Subject: Planning Application no. FP/212/20/OUT at 6 The Loop PO22 7ND

I wish to lodge an objection with Arun District Council to the planning consent application number FP/212/20/OUT for 6 The Loop PO22 7ND.

Extent of flooding from rivers or the sea

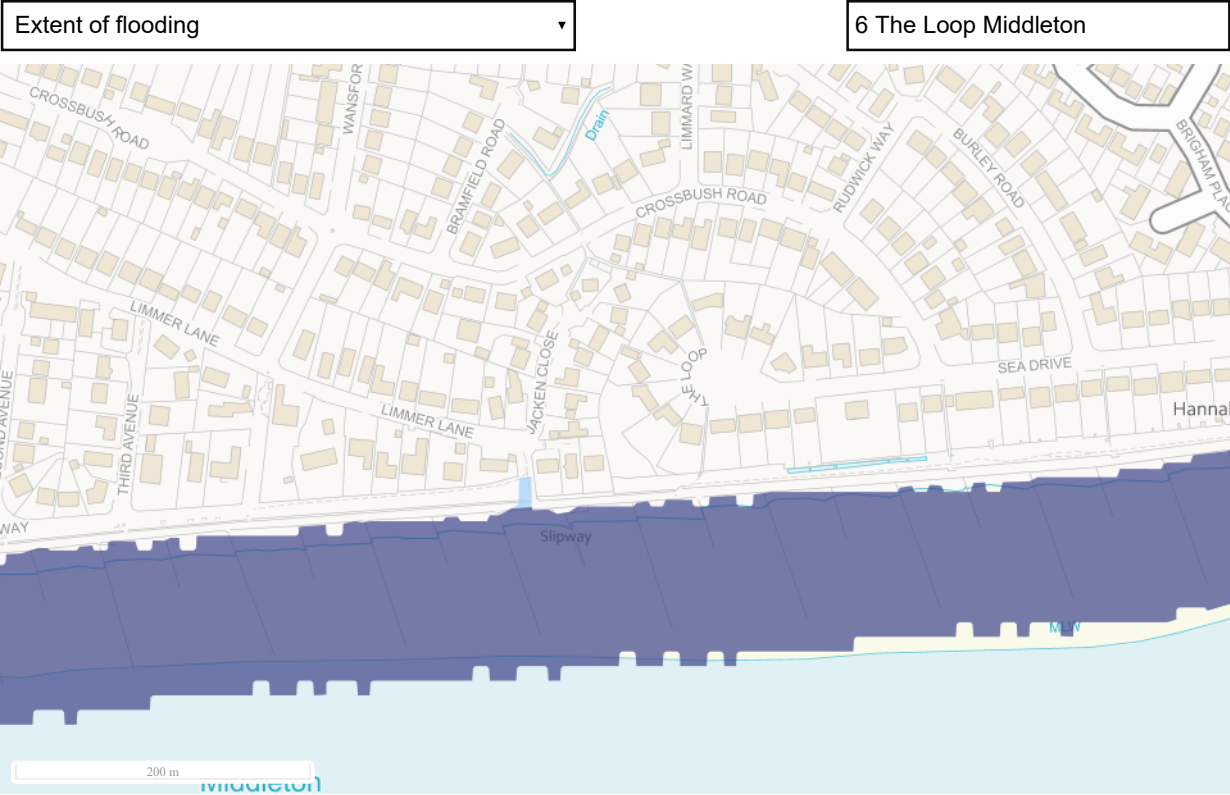
In the maps they have submitted, the first gives the impression it's not a flood risk area, and the second suggests
that the flood risk is low, your own drainage department, and Southern water are aware of the severe problems
with the drainage system in this area, and the concept of a soak away is amusing.
